From: Amanda Scholes on behalf of Planning.Responses
Sent: 27 November 2020 09:56
To: Planning Scanning
Subject: FW: EP/133/20/DOC- Scorton 9 Lime Tree Close East Preston BN16 1JA

Dear Chris,
Engineers have [provided the following comments regarding Conditions 8 and 9:
The details submitted are early revisions of what was previously submitted under EP/64/19/DOC. Please can the applicant confirm why the later revisions e.g. 4501-01 Rev C etc. have not been supplied with this application.

Drawing ref: LTC.U/GSERVICES. 002

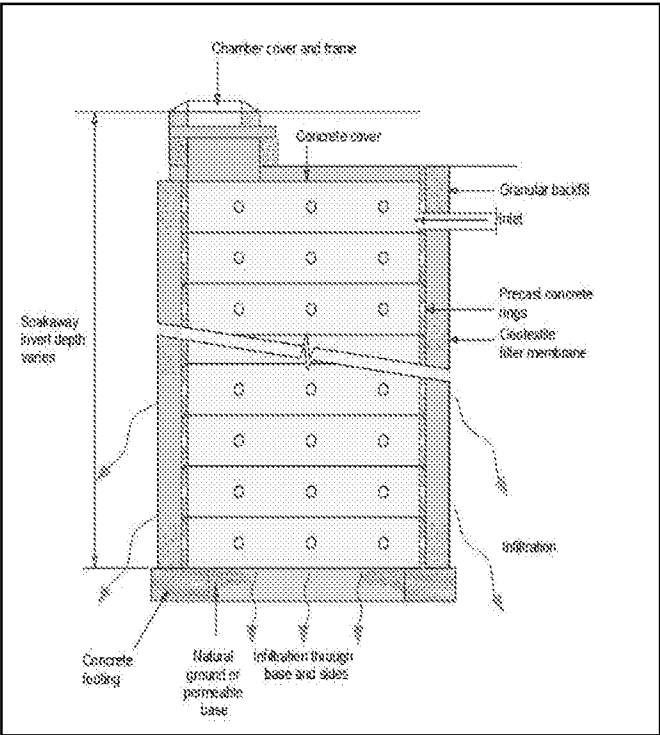
The application covering letter for this application states that the information submitted was previously deemed acceptable, this is incorrect, the later revisions were deemed acceptable.
